KITITAS COUNTY

MEMORANDUM

TO: All Staff
FROM: Justin Turnbull, County Surveyor 
DATE: August 23, 2017
SUBJECT: County Survey Review of Boundary Line Adjustment 17-00014 (Yakama)

RECORD SURVEY FOR A BOUNDARY LINE ADJUSTMENT FOR THE YAKAMA KLICKITAT FISHERIES PROJECT

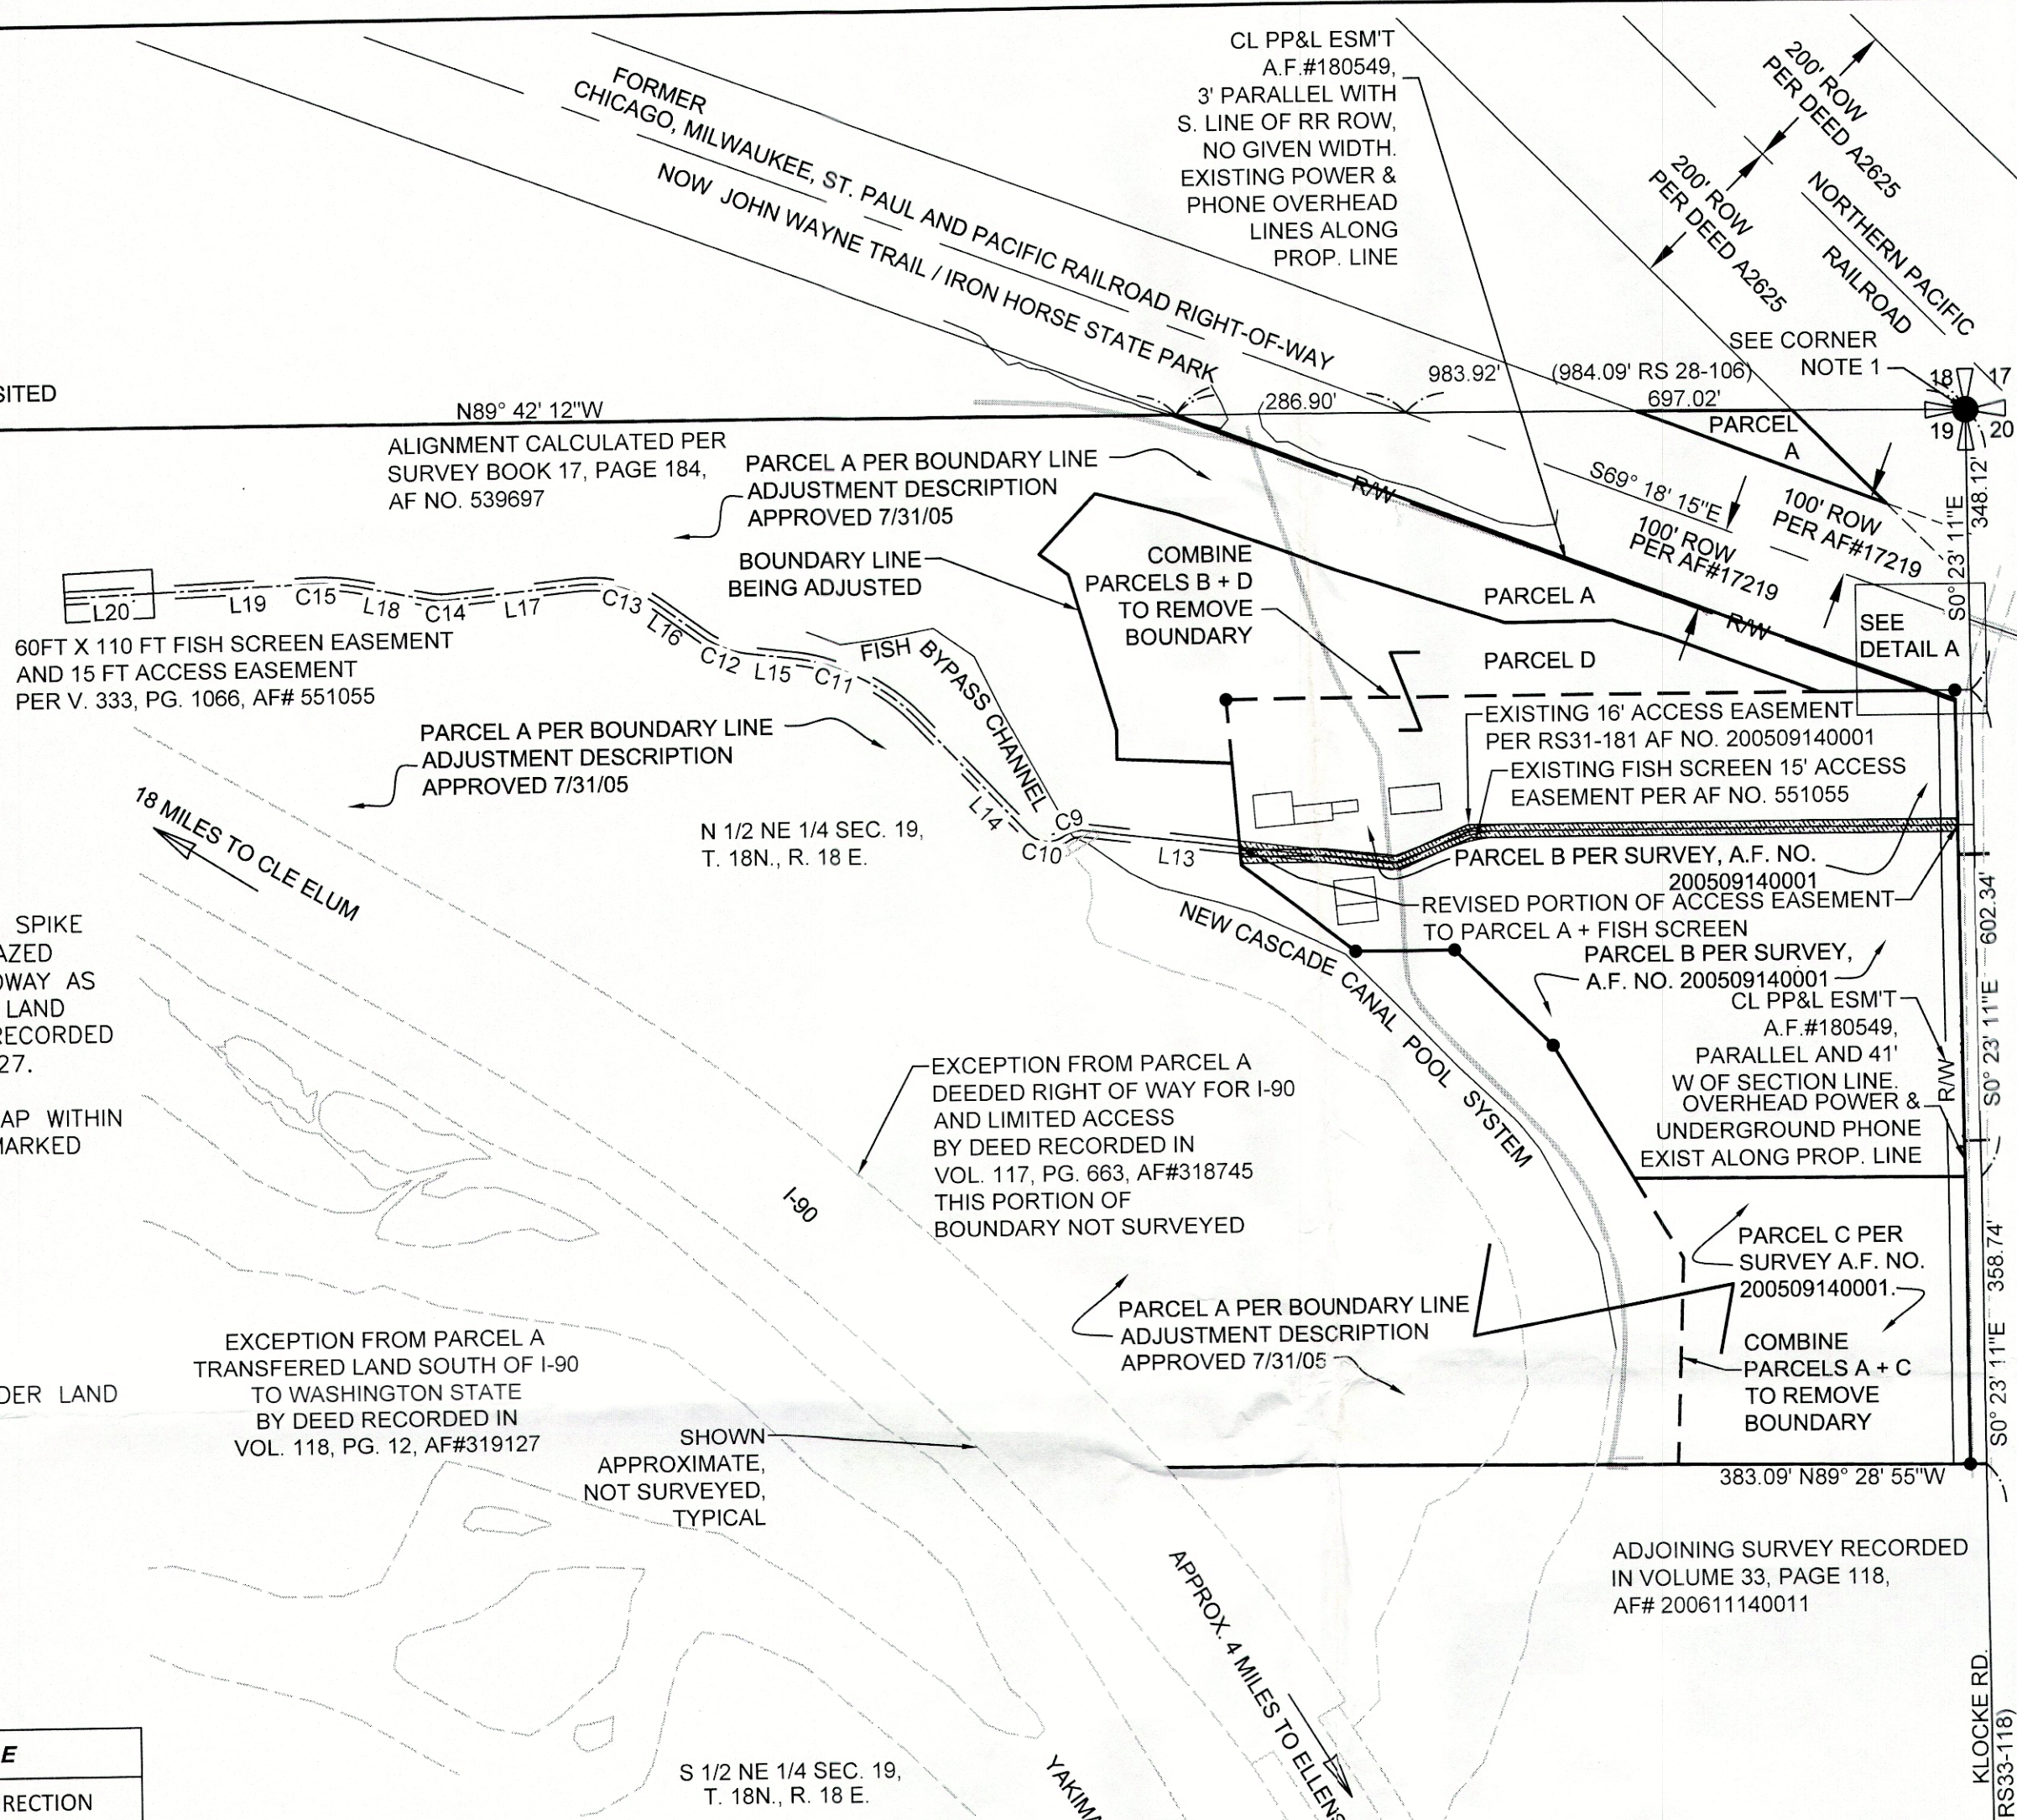
1. The West boundary of the 40' R/W for Klocke Road has been identified previously in Survey 33-118, and Short Plat A-64. Survey 33-118 has identified the SE property corner of Lot C as falling 3.5' inside the R/W. An extension of this line as identified would result in a loss from Lot C of a triangular portion measuring approximately 3.5' x 263'. The application as currently proposed will result in a discontinuous boundary along the West line of Klocke Road. If the applicant chooses to continue with this proposal as is, at minimum, the corner identified by Survey 33-118, should be noted (WAC:332-130-050(1)(f)(i)), and the method used to determine the limits of Klocke Rd be noted (held centerline of existing road/ held survey XXX).

2. Sheet 2 does not include a Legend.
3. Map should show areas of resultant parcels. In the case of Parcel A, approximate area would be suitable.
4. The boundaries (or approximate boundaries) of Parcel A should be visually shown, they do not need to be mathematically identified.

5. All roadways should show Road name, Width, Ownership, and surfacing material.
(EX: Klocke Rd. 40' County R/W – Paved)
6. At minimum the new division lines should be located and staked in the field.

7. The "revised portion of access easement" should include the language "created via separate document and include the recording number or a blanc space to be filed in at time of recording.
